**Recommendation:** Approve

**Applicant:** Peveril Securities

**Proposal:** Reserved Matters approval for 23/01080/OUT - Details of access, appearance, landscaping, layout and scale relating to the proposed development of Class E(g)(i) (formerly B1(a)) office/commercial building and Class E(g)(ii) (formerly B1(b)) Research and Development Units, plus associated car parking

**West (Entrance) Elevation**

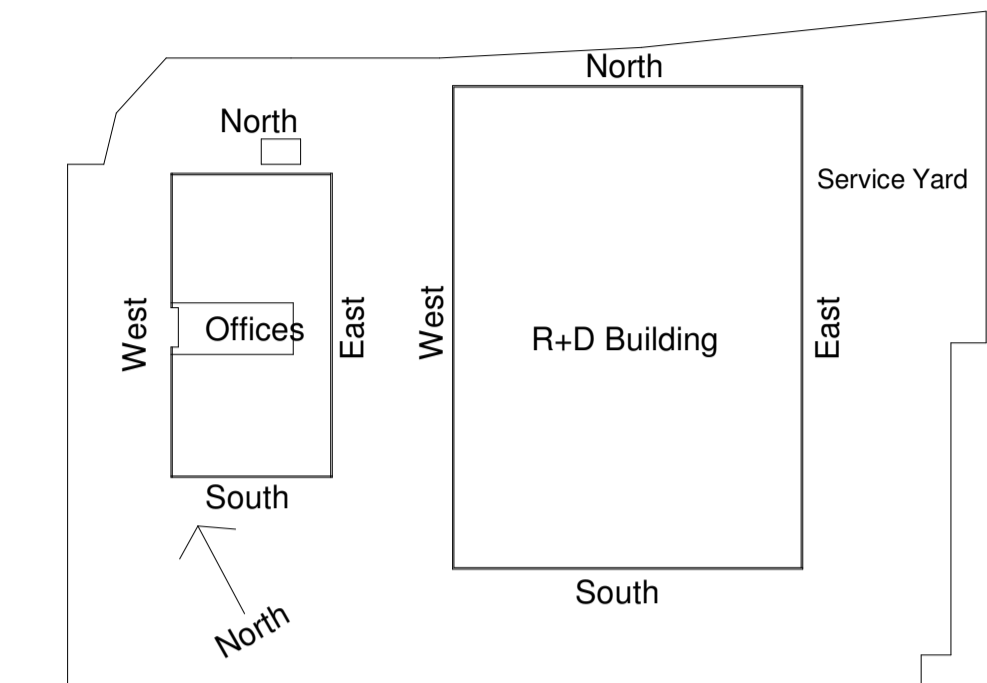
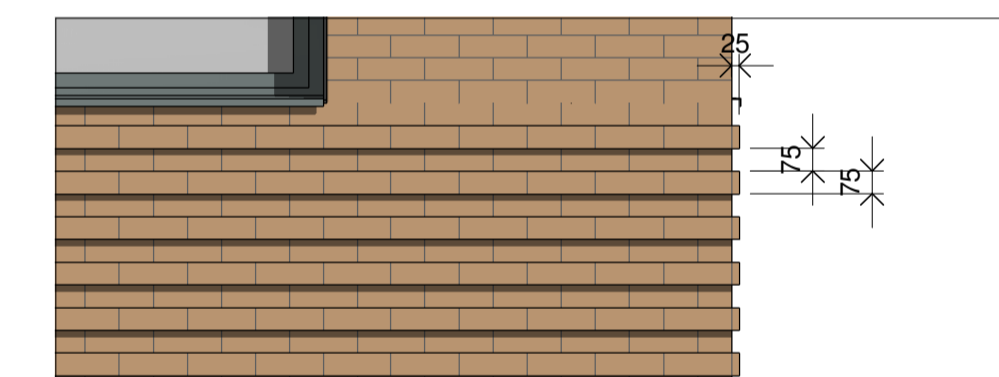
- 8.13. Building A (the office building) comprises 4 storeys with a roof plant on top, partially screened by mesh railings. In design terms, each floor repeats itself up to the top of the building.

- 8.14. In between each floor there will be strips of projecting stretched bricks which help provide visual relief and provide visual interest to the elevations.

- 8.15. The large, rectangular windows, which will be conditioned to be inset are attractive and of an appropriate size.
- 8.16. Both the east and west elevations contain a central Curtain Wall with an Aluminium Framing Colour RAL7009

Elevation - West
1 : 200

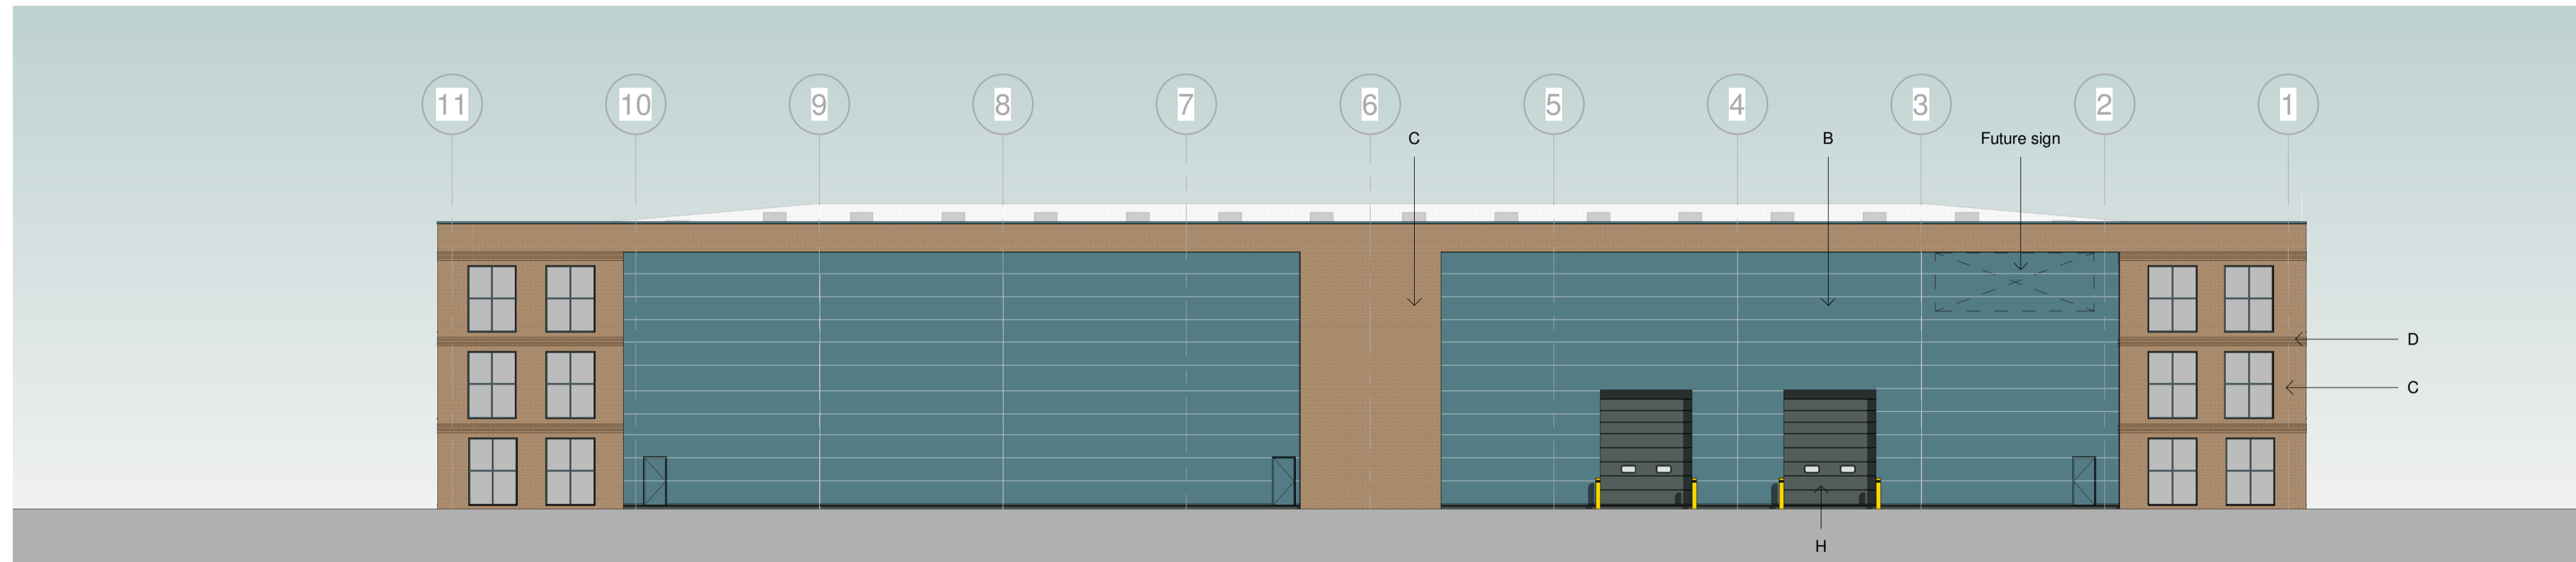
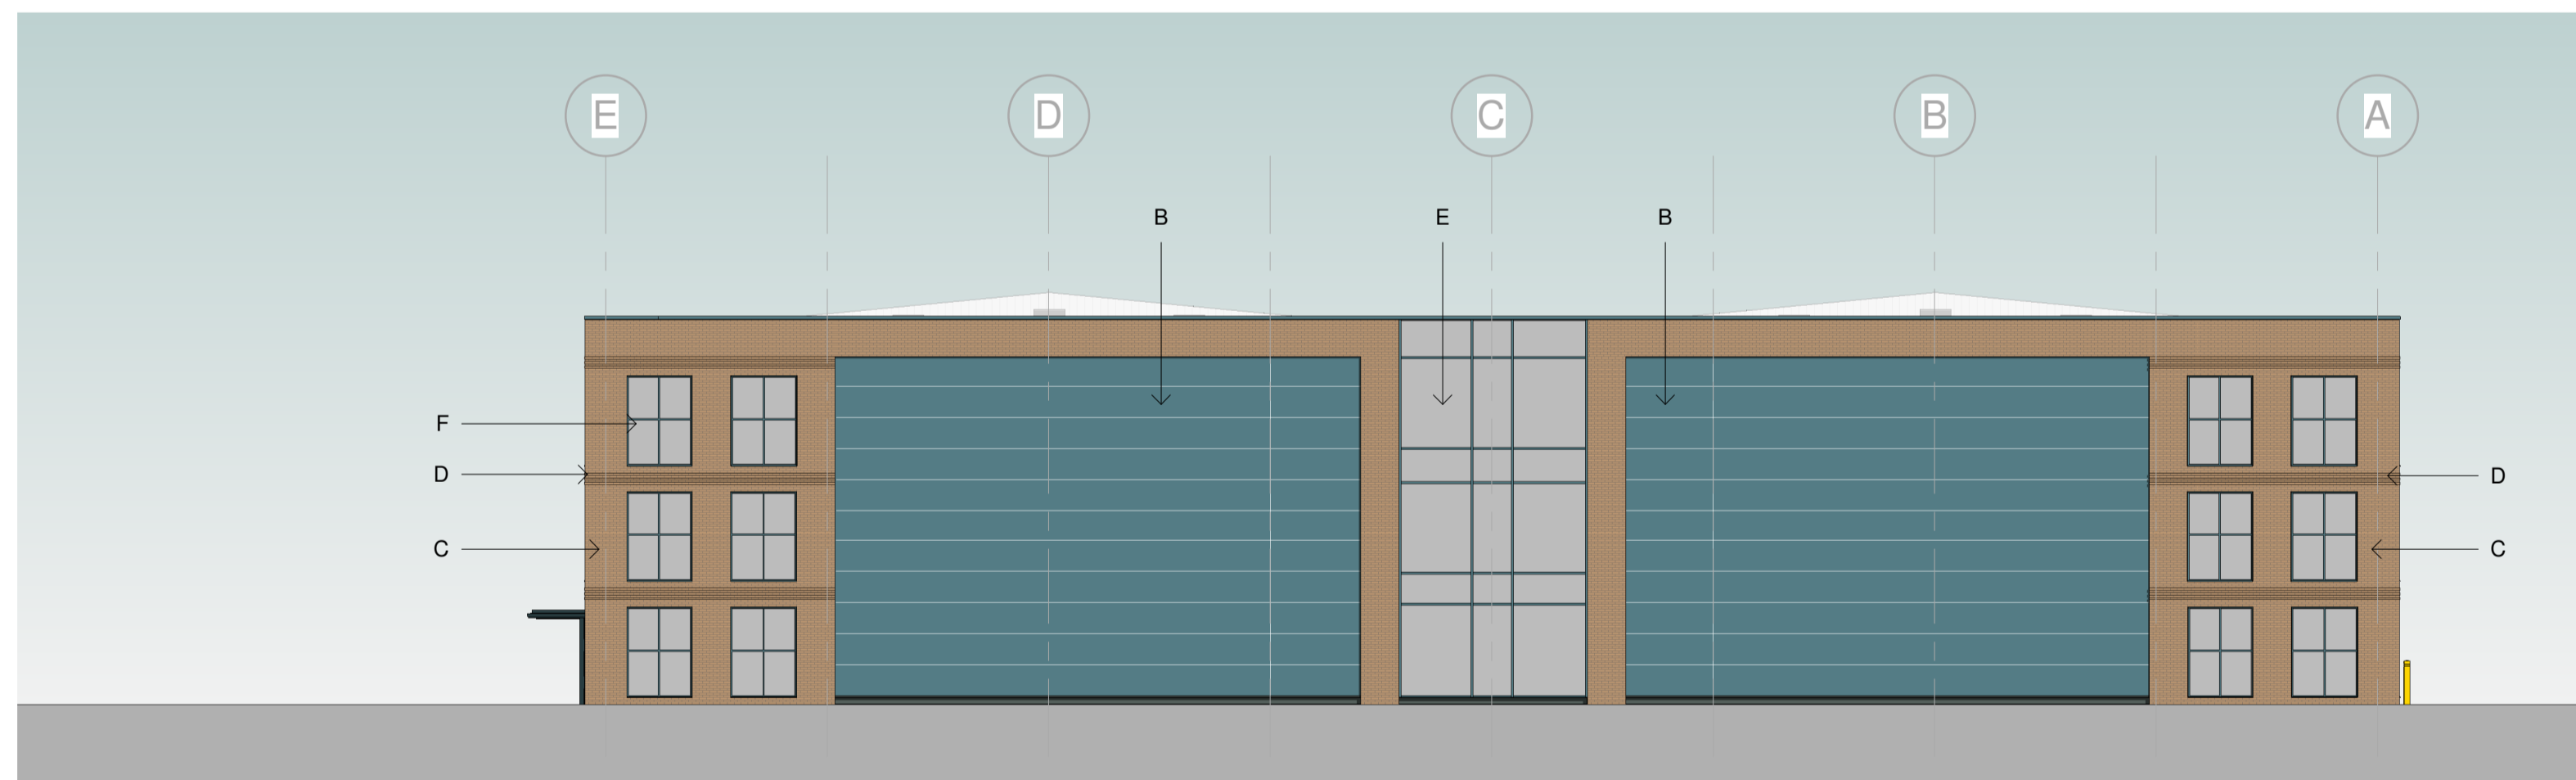
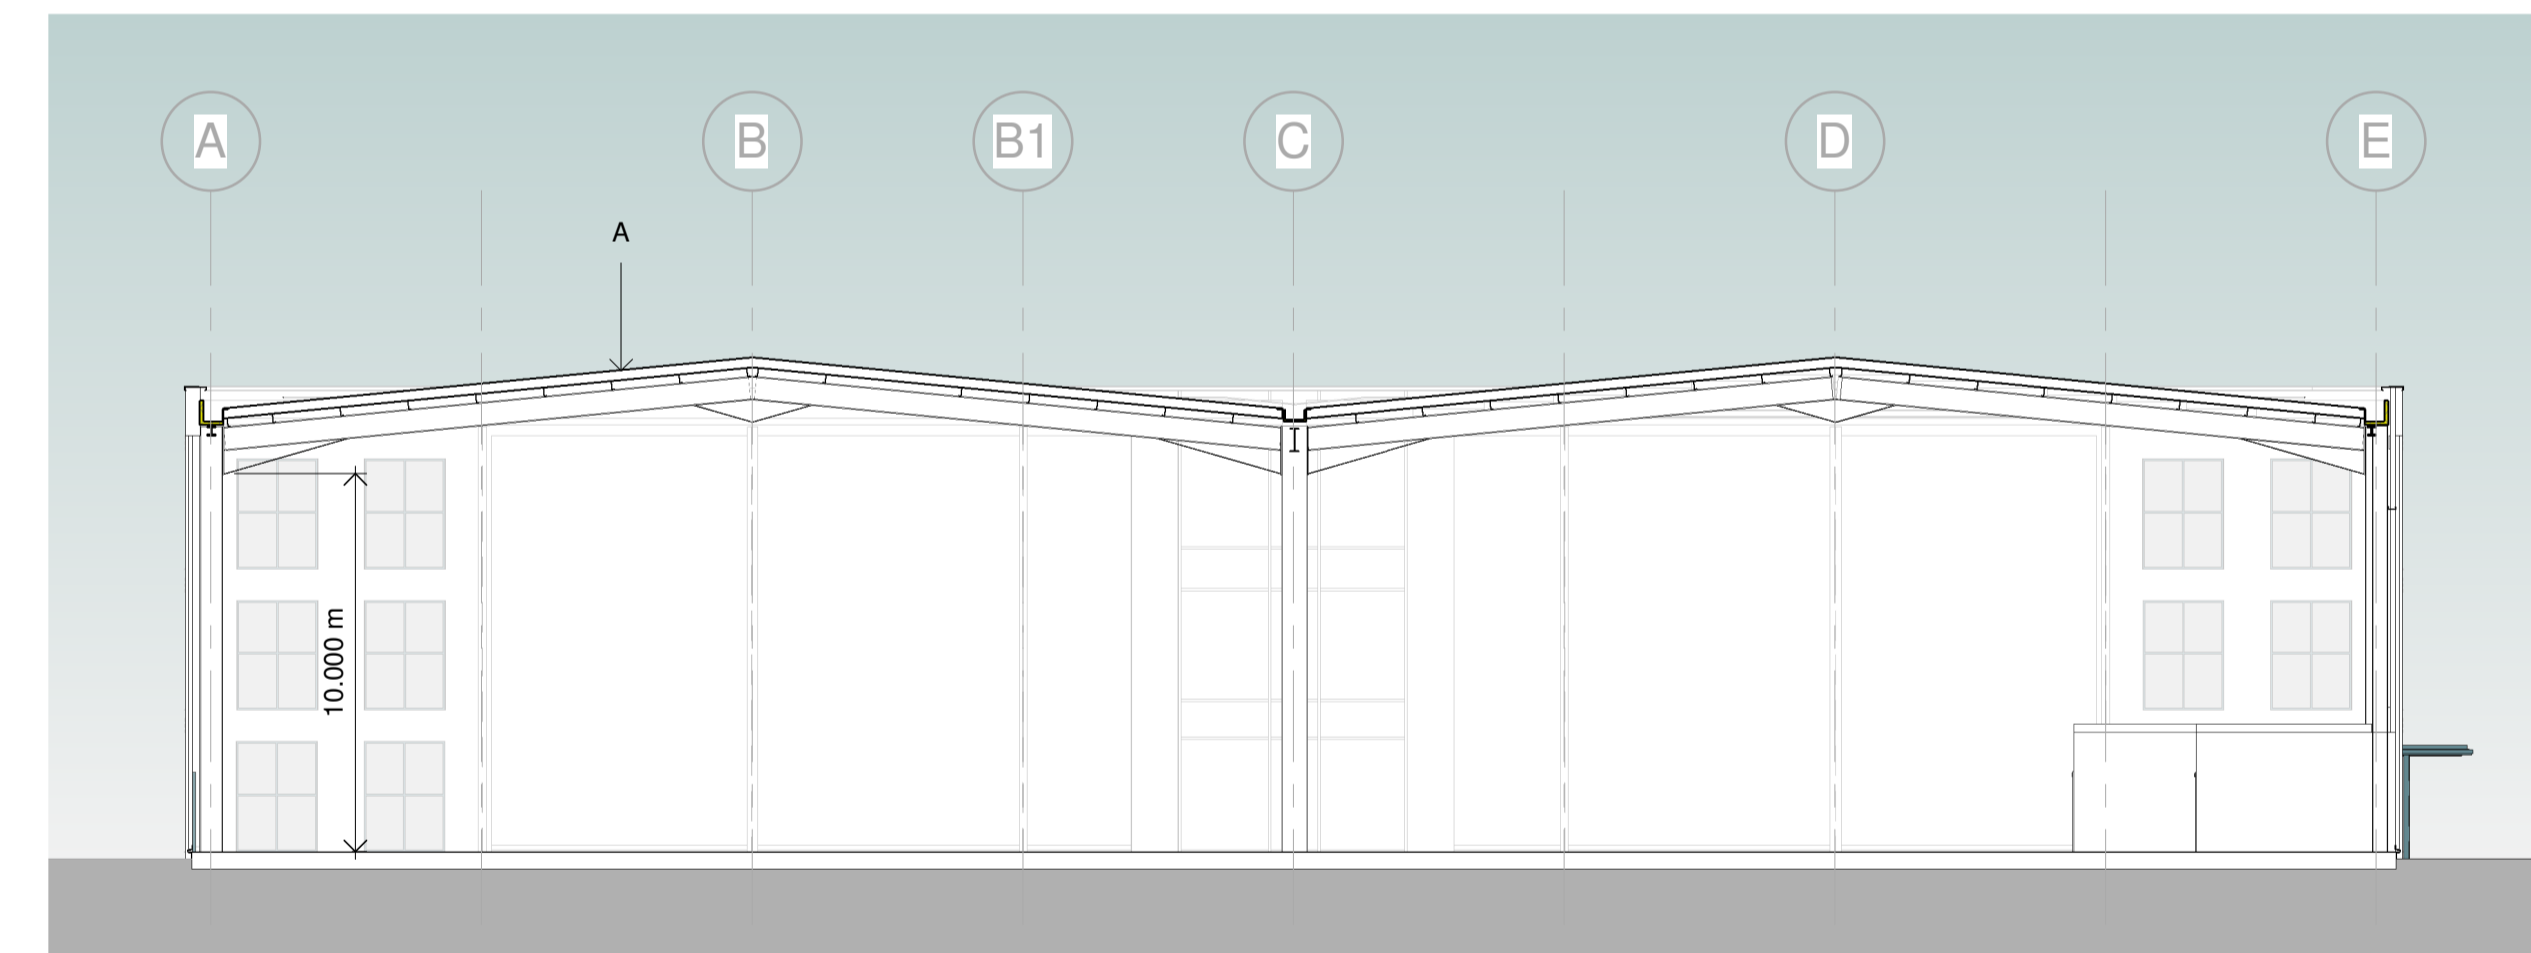
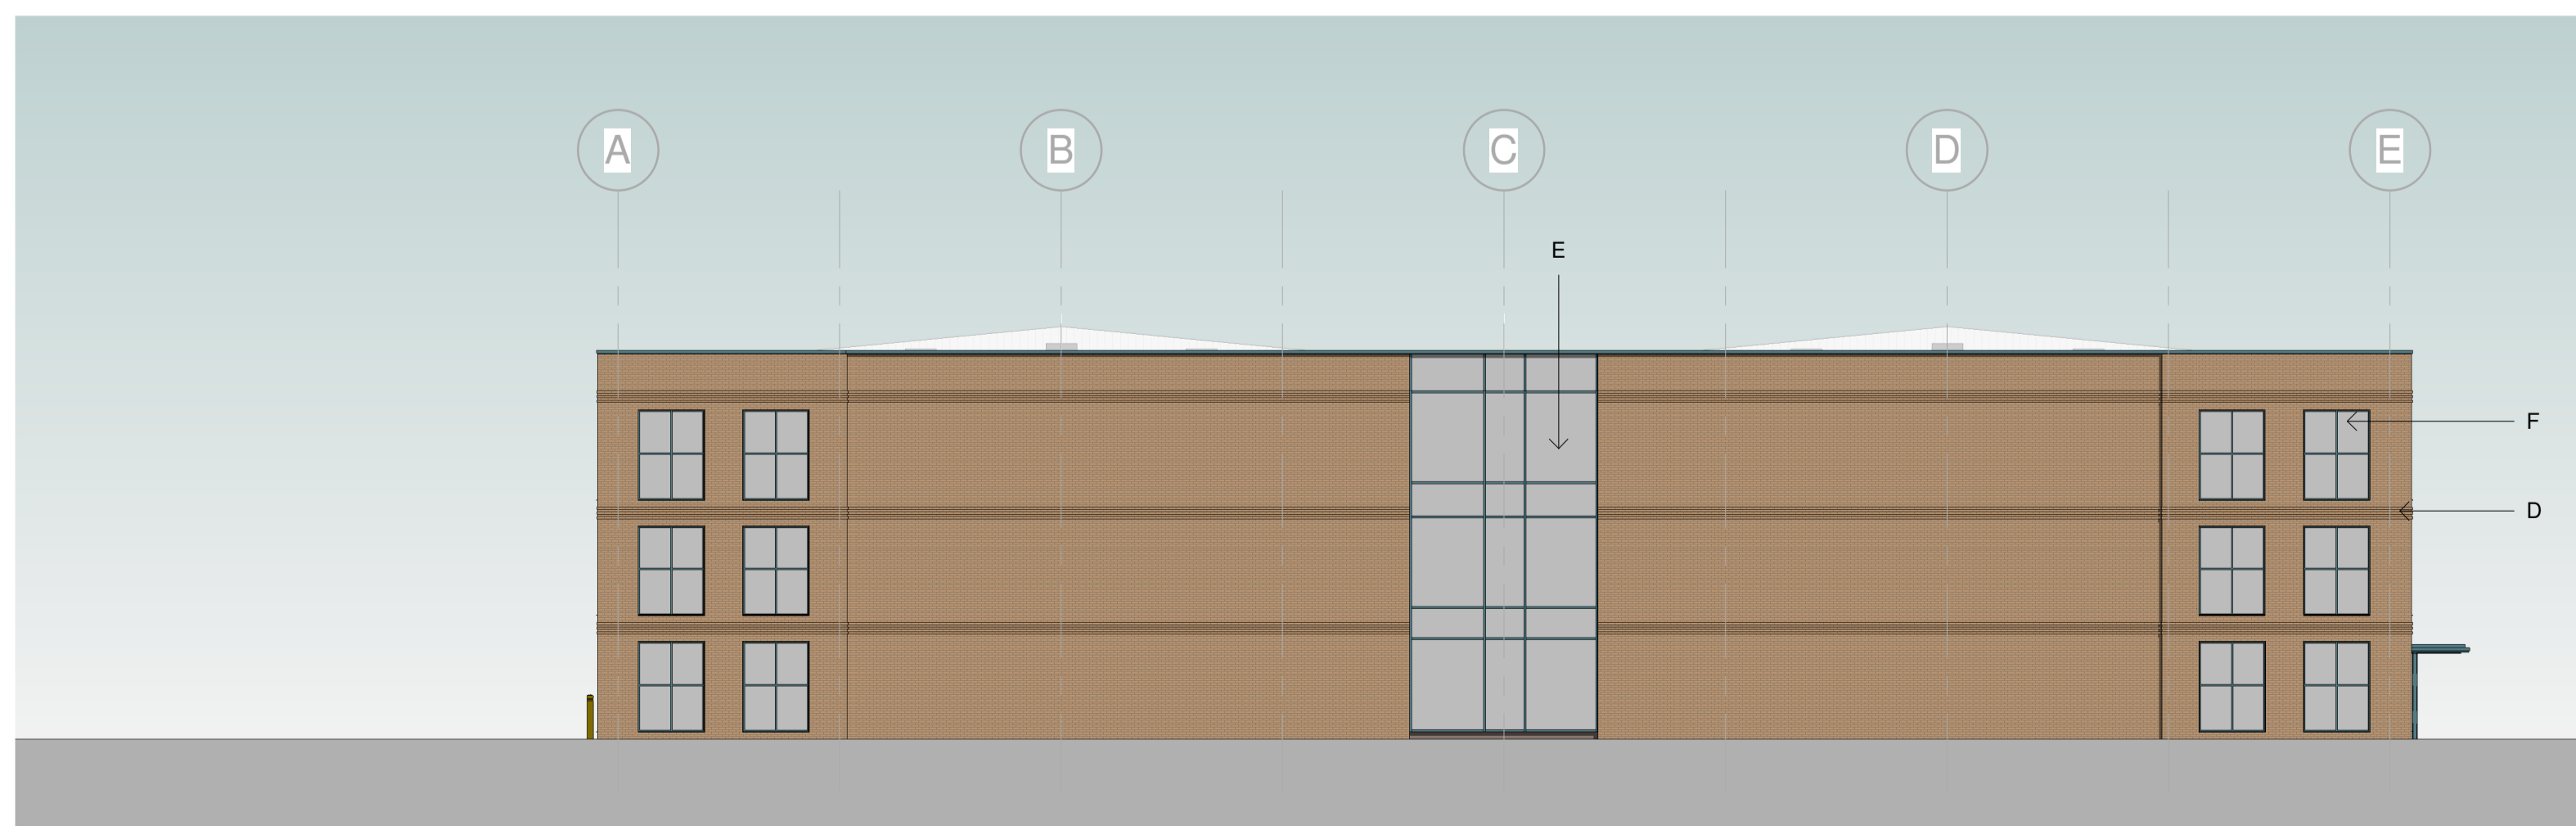
- 8.18. Building B (the R&D building), despite being lower in height, is much larger in scale and occupies a greater ground floor area. Given the scale, it is imperative that this building avoids being functional and sterile in appearance.

- 8.19. The applicants, and the officers, have worked together and, following receipt of several different design iterations, Building B now avoids being a defensive building and, instead, will be of some visual interest.

- 8.20. The north and south elevations are both broken up by a central Curtain Wall with an Aluminium Framing Colour RAL 220 50 15. These two elevations are bookended by three floors of opaque rectangular windows, which is an acceptable design treatment.

- 8.21. The east and west elevations are longer in length and comprise a mixture of buff brickwork, Horizontal Cladding (Insulated Panel: Finish MicroRib Colour RAL 220 50 15) and three floors of rectangle shaped windows which, for security reasons, will be opaque glazed.

- 8.22. The roof will have a very gentle pitch and will comprise insulated cladding with trapezoidal outer profile: Colour Goosewing Grey.
- 8.23. A series of 3D images have also been submitted to demonstrate how the proposed buildings sit in the immediate context and from vantage points further afield. The combination of good hard and soft landscaping (described further below), varied elevational treatment and the siting of the two buildings, means that the overall response to the wider context is acceptable in design terms.

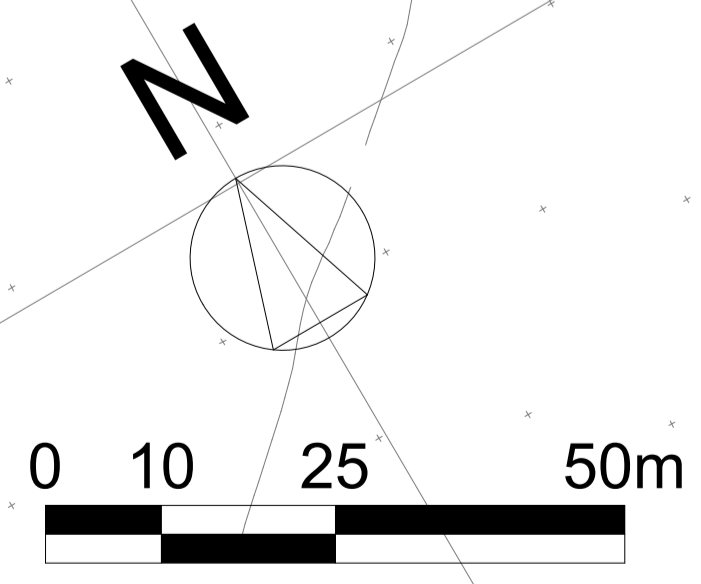
- 6.41. *I am encouraged by the design of the 'landscape finger' swale and trees (Yasa Landscape GA Plan) and would like to see how this work as the route towards the west and also how it links with the Ecopark to the east. Whether it is possible to extend this theme westwards? The meandering cycle and walking route will require good vis splays for cyclists and pedestrians, therefore the ornamental/native planting so kept to medium to allow for views across the route. Also how the swale is connected the proposed drainage system, or just surface water runoff.*

- 6.42. *As for circulation I would recommend other pedestrian path connections (two) between the route and the YASA site to encourage to use of this recreational route from the YASA site without feeling the need to create unsightly desire lines – refer to marked up plan. I would hope the route becomes popular for lunch breaks for site users during the summer months and the route may require more seats to encourage this activity.*

- 6.44. *Tree roots (Populus tremula) will spread under the route potentially lifting and breaking the surface unless root deflectors are installed as part of the tree pit detail. Alnus glutinosa tends to lean over as it grows and may not be appropriate near a pedestrian route because of this. I suggest replacing with A. cordata.*
